Subject: Objection to Planning Application

Formal Objection to Planning Application – 143 Church Lane, Gomersal 2026/62/90484E

Alterations and Extensions to  
143 Church Lane Gomersal, Cleckheaton,  
BD19 4QN.

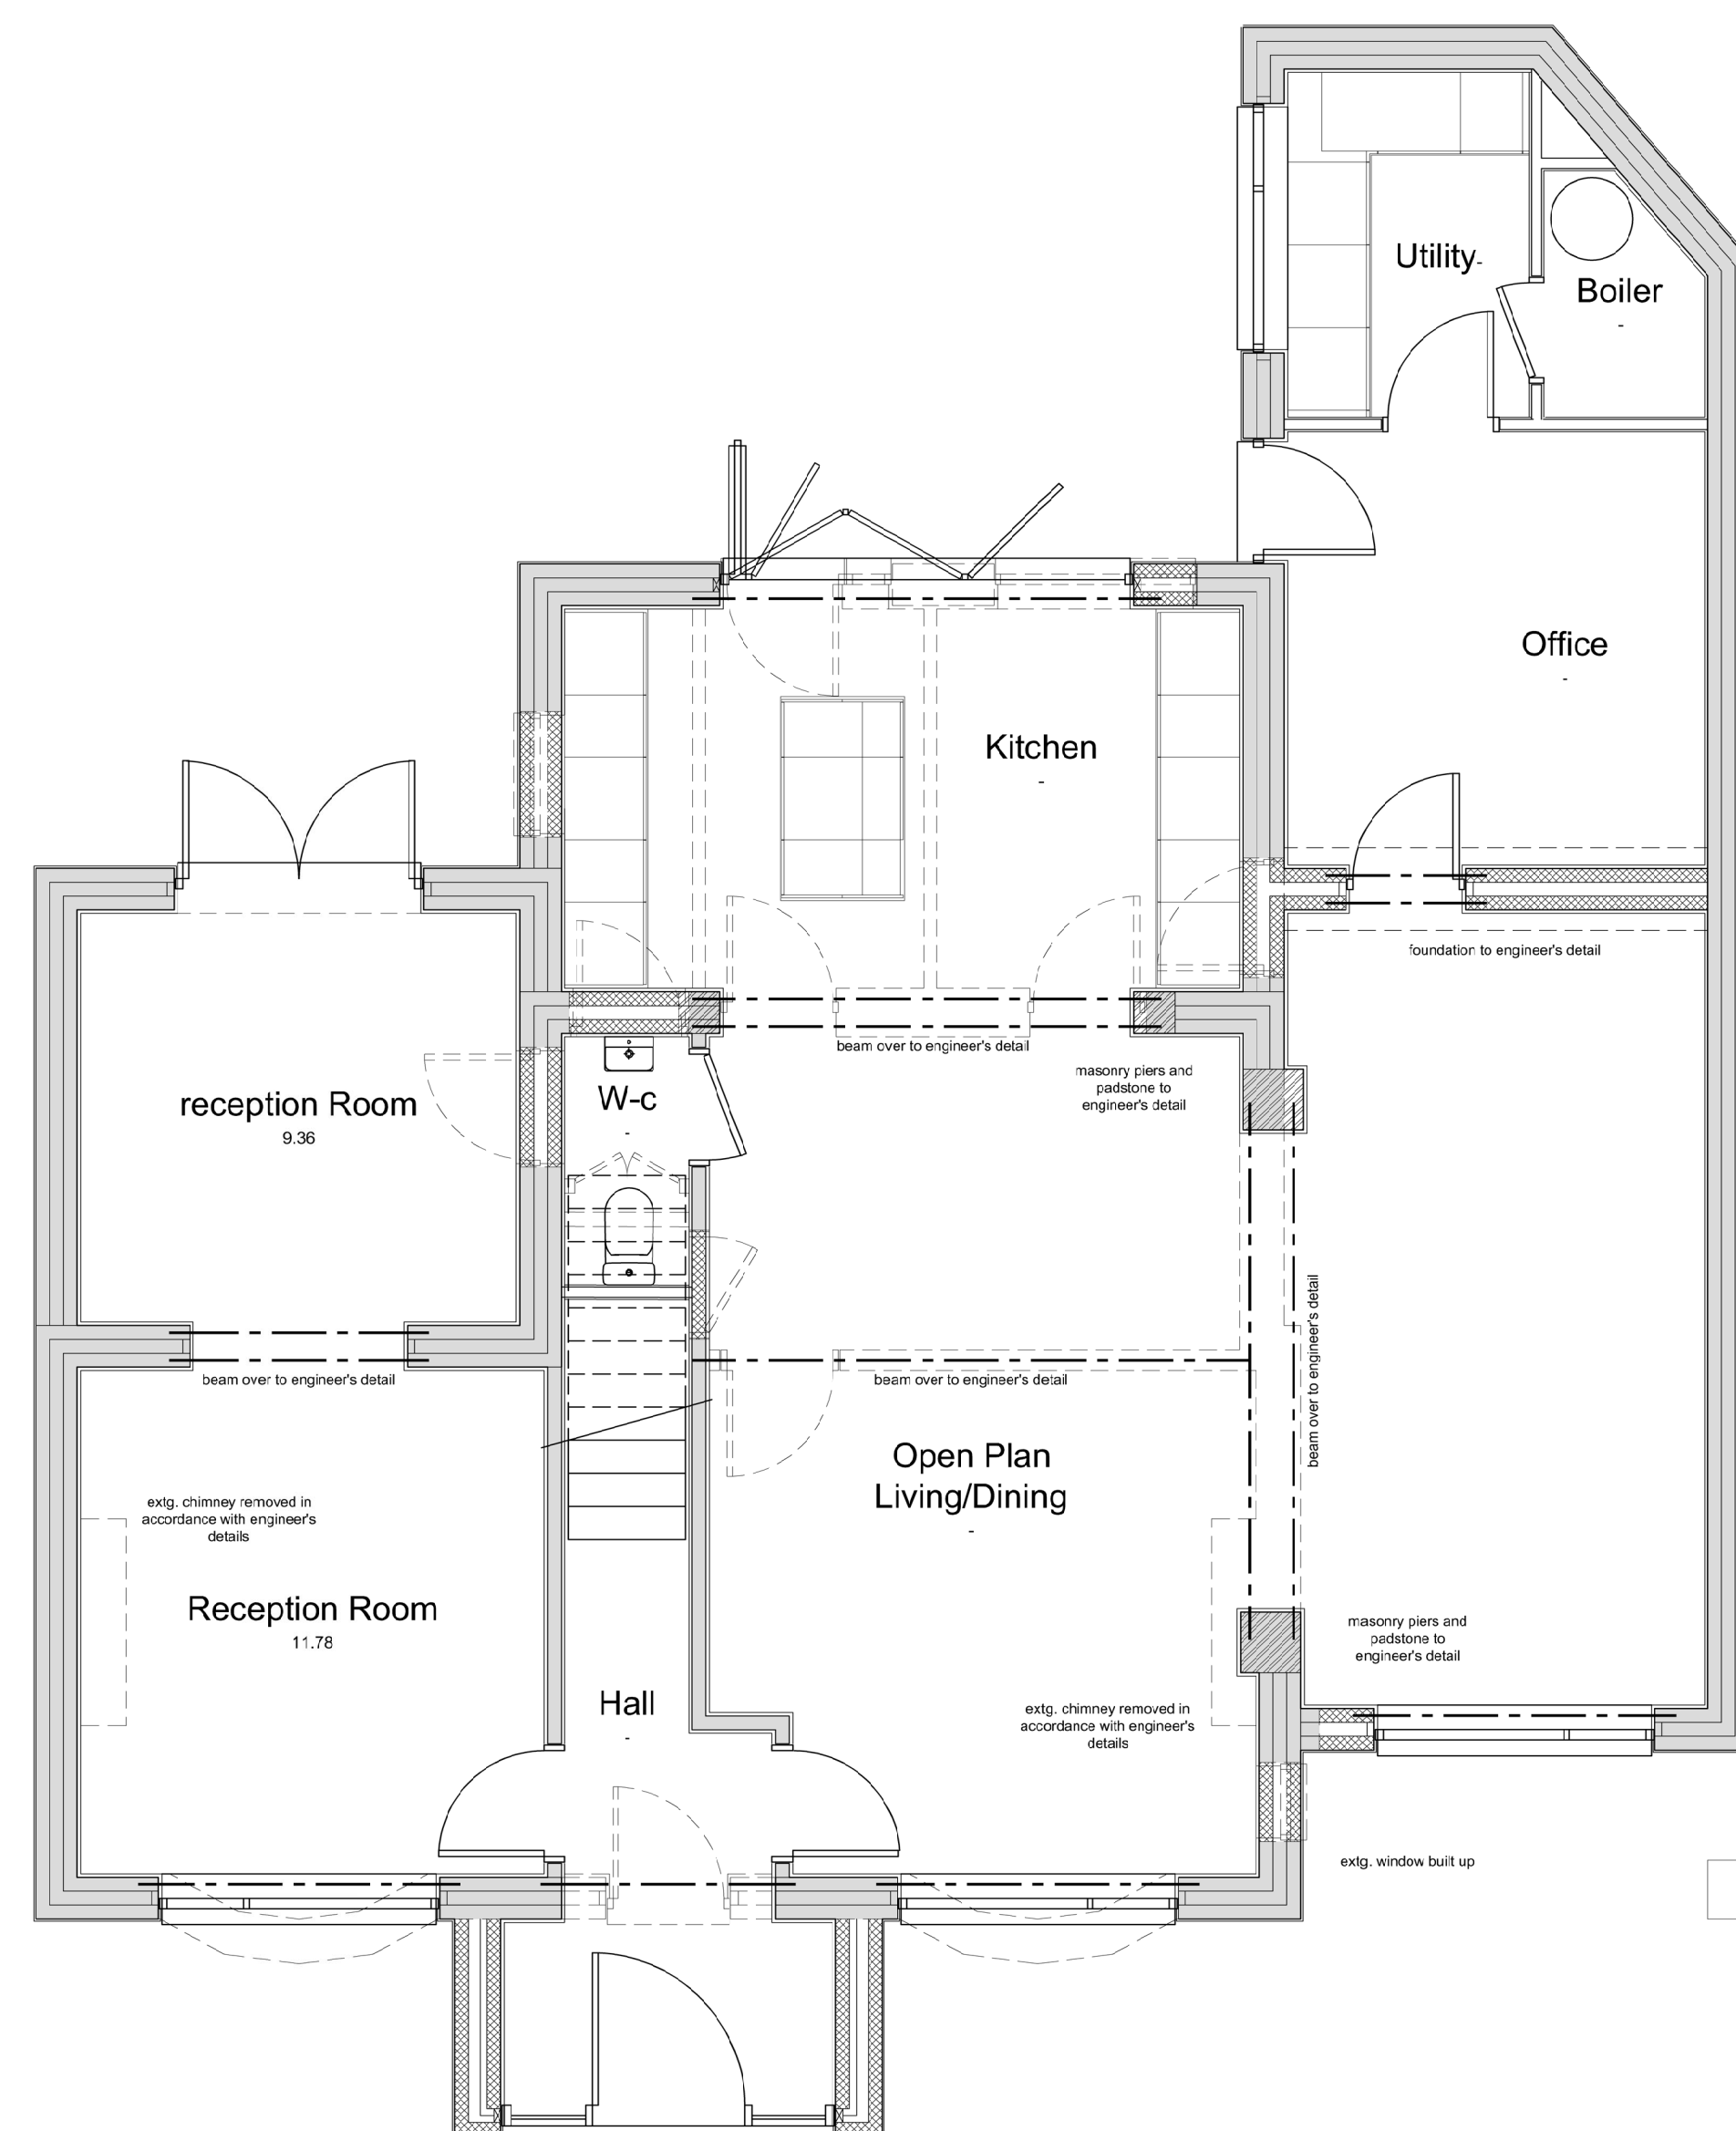
After reviewing the proposed plans and carrying out a visual inspection of the property, it is evident that there are no apparent escape routes from the rear of the building as the side elevation only provides around 750mm of clearance between the existing garage and the boundary line, which is not adequate as an emergency escape route.

Furthermore, the property would require fire-escape compliant windows for all bedrooms. Several of these windows would fall outside the proposed secure fencing and gated areas,

creating significant safety concerns and presenting potential escape risks for vulnerable residents should they wish to leave of their own accord.

The application claims an additional parking space has been created, yet the garage which could have provided parking has been converted into a room. In reality, the property still only offers two on-site spaces.

The plans also indicate controlled gate access for entry and exit. This will further reduce usable outdoor space, in addition to the area already lost to parking.
